From: Planning
Subject: FW: Inglemead - off Waddington Road Clitheroe (app20/1015)

From: Bloomer, David <David.Bloomer@lancashire.gov.uk>
Sent: 21 January 2021 11:44
To: Stephen Kilmartin <Stephen.Kilmartin@ribblevalley.gov.uk>
Subject: Inglemead - off Waddington Road Clitheroe (app20/1015)

Drawing No. A200 Revision A

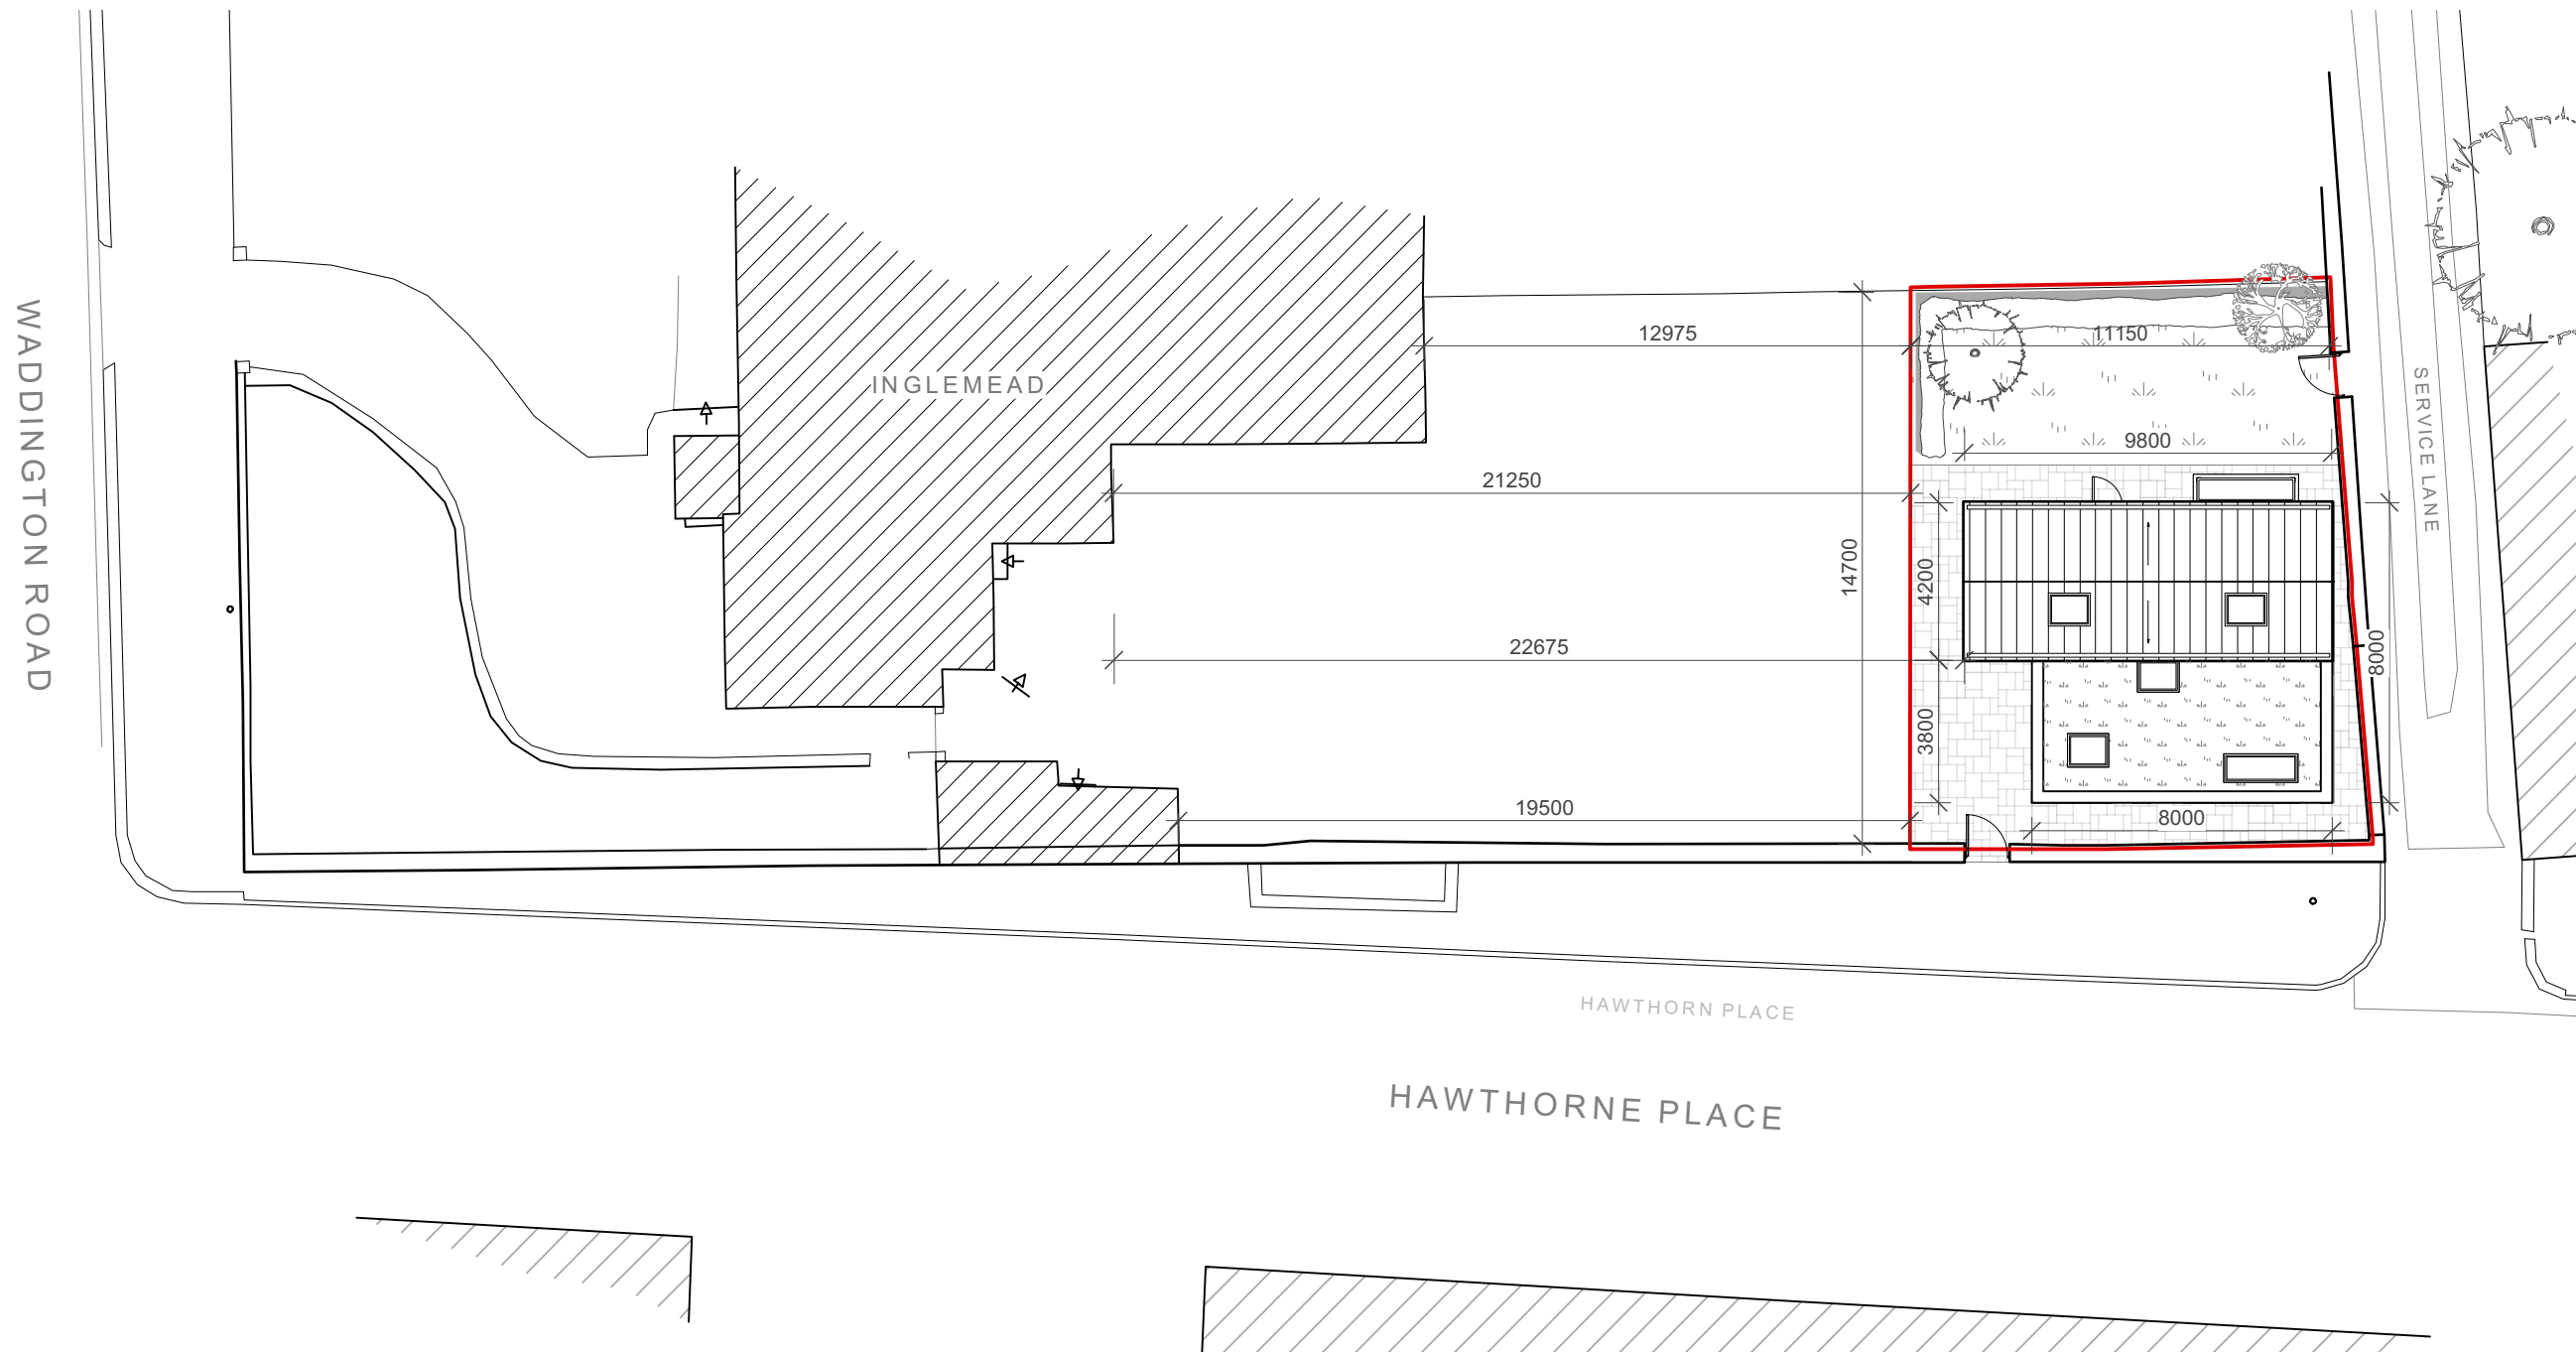
Thanks for your phone message, the amended plan removes any parking provision within the site. In my earlier response dated 17th Dec I made reference to the fact the size of the dwelling would ordinarily attract a parking provision of 2 parking spaces but that the proximity of the town centre and sustainable location would support a reduction to 1 vehicle. Unfortunately this concession could not be extended to a zero parking provision . In coming to this view I have taken account of the existing parking demands along this section of road , and the proximity of the proposed site to the junction with Waddington Road.. There is space in the rear garden which if acceptable may provide the necessary parking space but the restricted width of the back street and the surface condition would need to be taken in to account in any design process.
